## A66 NTP: Cumbria County Council - PRINCIPAL AREAS OF DISAGREEMENT SUMMARY STATEMENT – UPDATE FOR DEADLINE 3

Drawing Title: De-trunking Plan Regulation 5(2)(o) Sheet 1 of 1

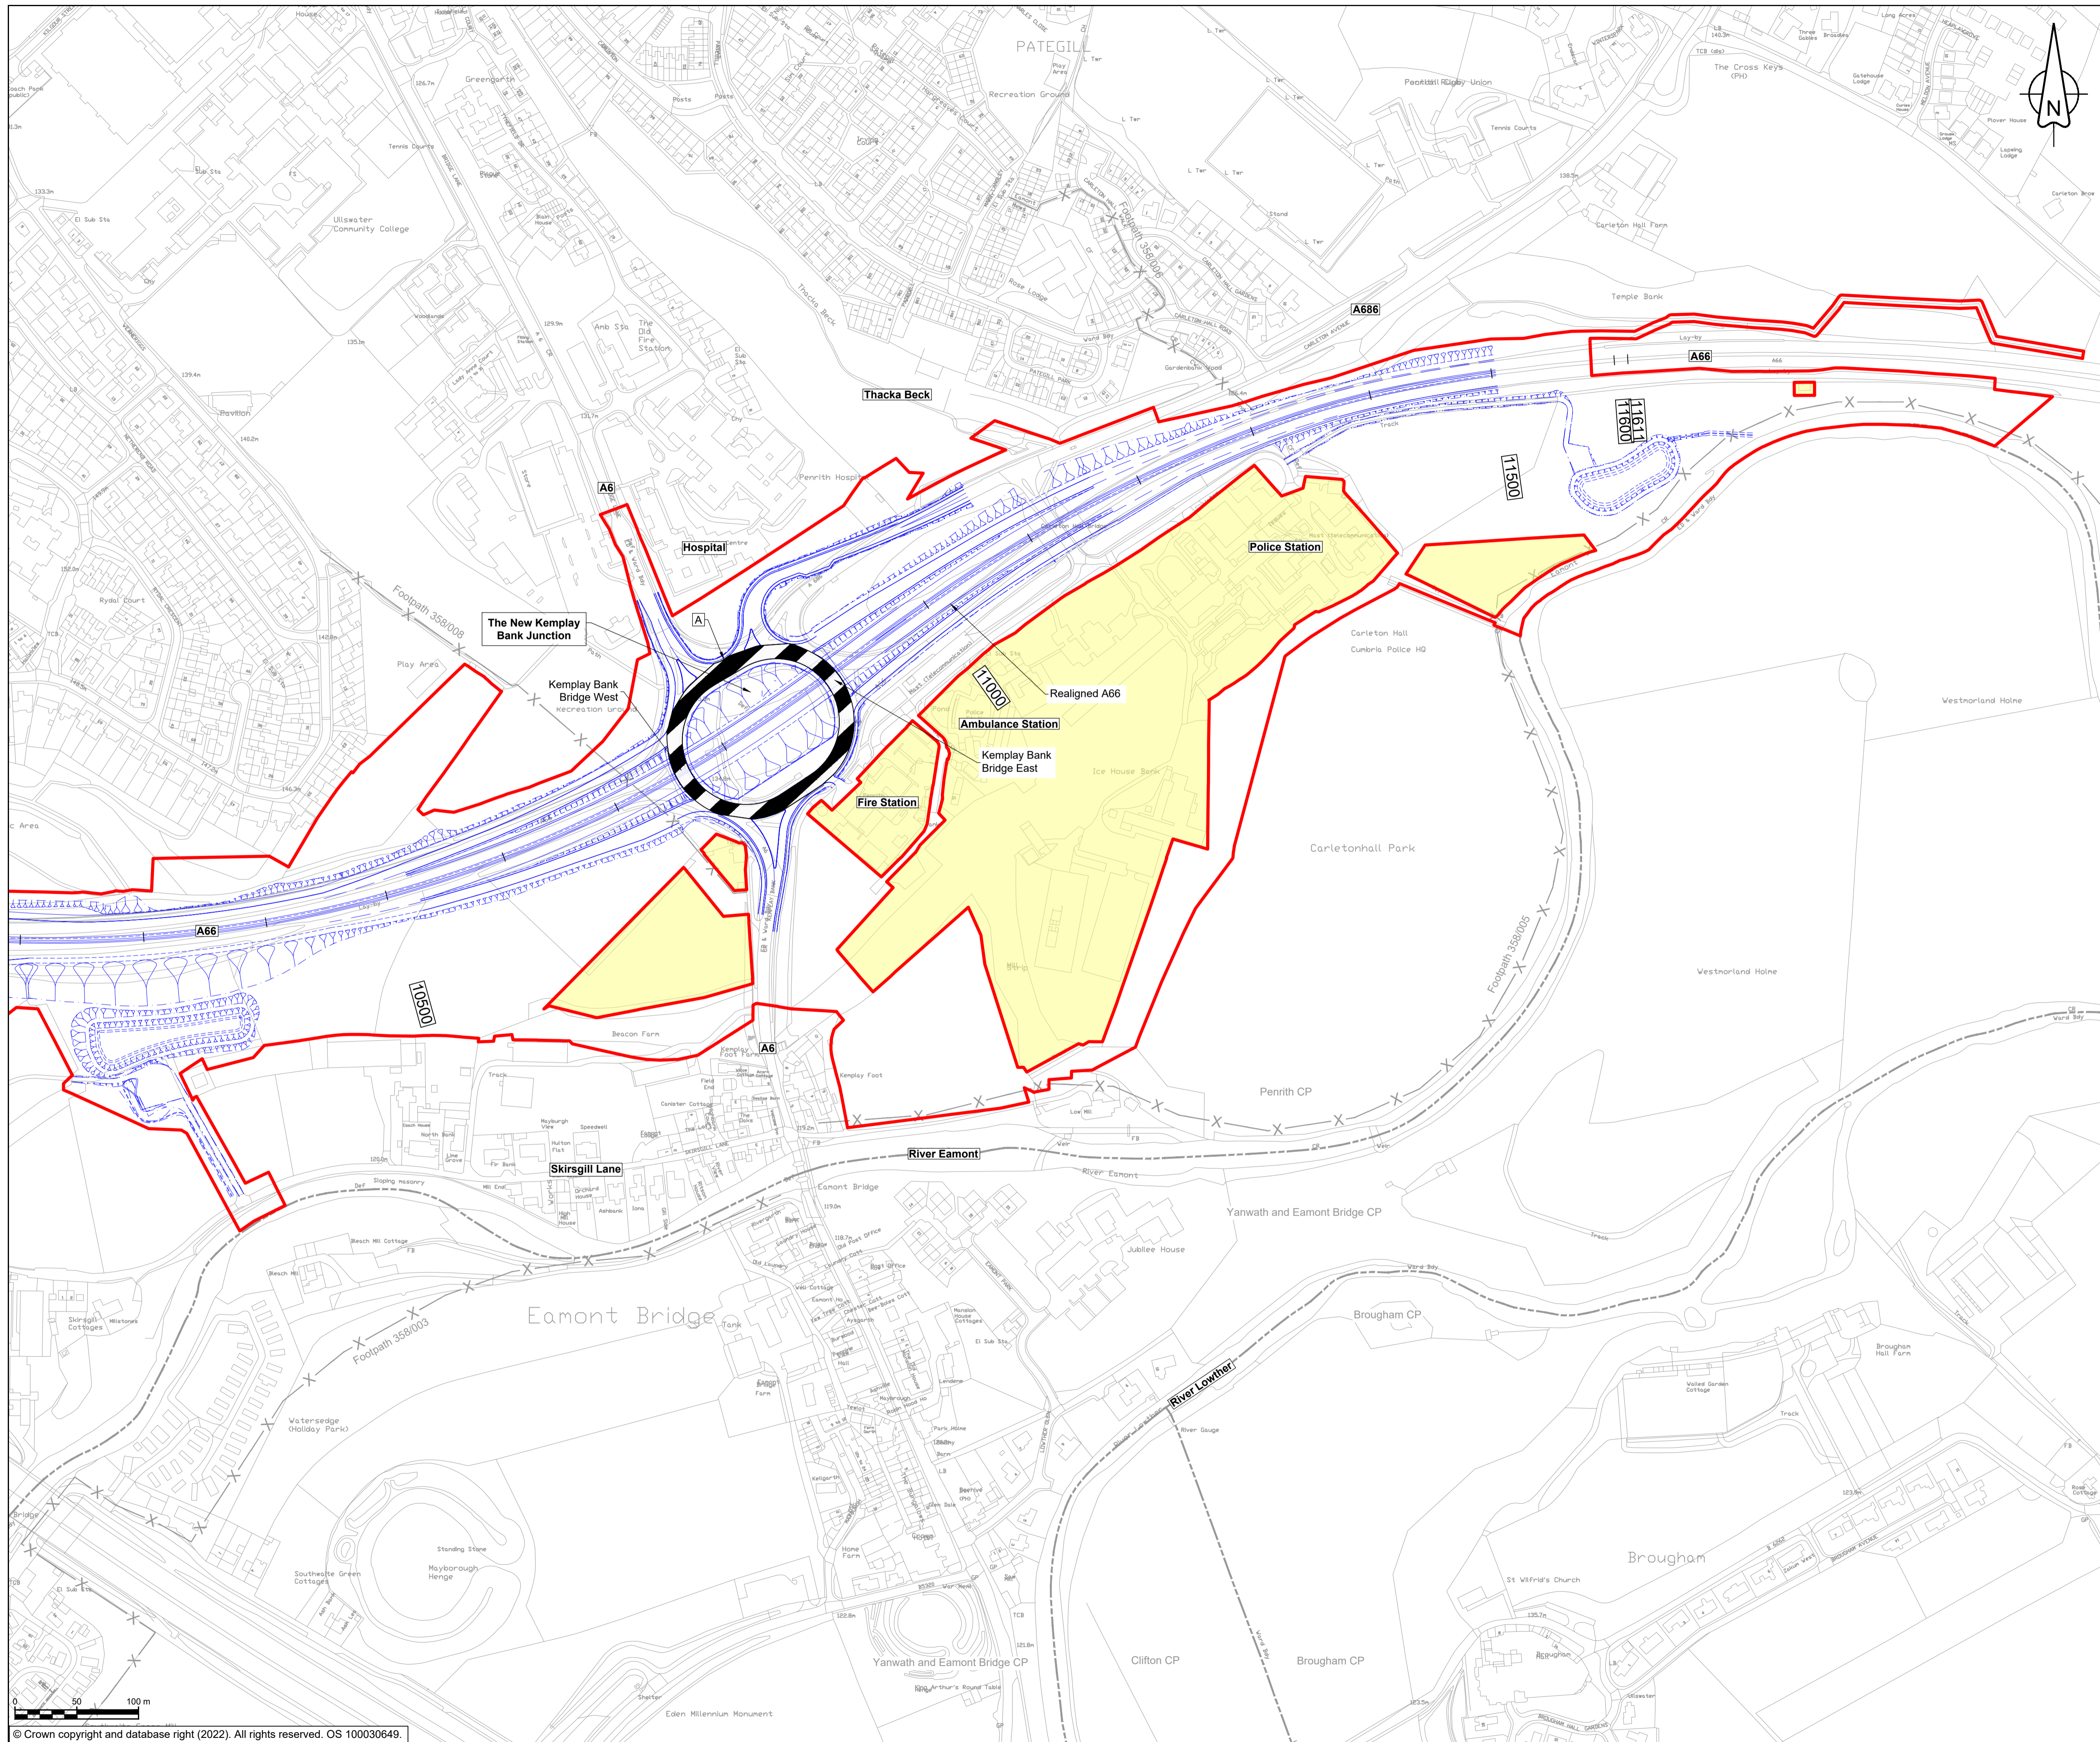
21	<b>Detrunking (road and structures)</b>	Lack of clarity as to what assets will transfer to the Council as a result of detrunking. The Council needs to be assured that the detrunking proposals are acceptable in respect of: 1. Maintenance liabilities 2. The condition of the detrunked assets 3. The design suitability of the asset (appropriate to the proposed use) 4.. The provision of funds to maintain the asset.	There is a need for continued discussion and negotiation with NH to agree the over-riding principles for detrunking. A detrunking principles document and implementation of the process for agreeing detrunking needs to be secured through the DCO process provide the Councils with a commitment or funding to bring the de-trunked sections up to an acceptable standard before handover and adoption. The condition of the proposed de-trunked sections ( including carriageway surface, lighting and associated infrastructure) needs to be independently assessed. Before accepting the asset, there will need to be a full condition survey and joint agreement on how any required repairs or improvements will be implemented and funded. Need to understand deterioration of the asset once construction work commences until the handover date. Furthermore, the extent of de-trunking needs to be discussed and agreed with the Councils prior to establishing de-trunking agreements. it is understood that NH will prepare a 'Detrunking and Asset Handover Approach' and 'Asset Adoption Plan'. The Council needs an opportunity to review these documents and agree the approach for subsequent approval. Need to confirm that the application red line boundary includes all the detrunked assets.	The Council's principles document was produced in 2022 to initiate the discussion on de-trunking with the Applicant without any insight to the Applicant's strategy. The Councils did not have any feedback on the document but welcome the discussions which are now progressing well on the technical aspects of the different assets to be included in the de-trunking process. The examples of residual serviceable life issues noted The Councils will continue to engage with the Applicant as the design progresses to ensure that the standard of provision provided meets the standards within LTN 1/20. The examples of residual serviceable life issues noted here by the Applicant have already been discussed and, along with other aspects, are in the process of being resolved with the Applicant. The Councils believe that the requested funding from the project to support improvement to sub-standard assets and for their ongoing maintenance after handover is a justified use of taxpayers' money as it will go through the rigorous local highway governance process and efficient delivery processes.  The consequence of the Project to significantly increase the assets to be maintained by the Councils should have direct compensation and not be reliant on unsecured future funding strategies.

<b>Detrunking (road and structures)</b>	Future Maintenance - the Council must not inherit a maintenance liability and must be funded appropriately to maintain the de-trunked assets.	Review the detrunking strategy or other relevant documents produced by NH to confirm the acceptability of maintenance provision and agree the mechanism for payment of commuted sums for maintenance	See above comments.
22	<b>Public Rights of Way (PROW)</b>	Lack of clarity on the acceptability of PROW proposals, including severance issues, route diversions, and the condition and maintenance of diverted PROWs	The Council needs to understand the impacts on PROW and confirm the acceptability of NH's proposals. Discussion will be needed to resolve any outstanding concerns	The Councils require further information and discussion on the diversion issue before it can confirm their position, including the PROW Management Plan.
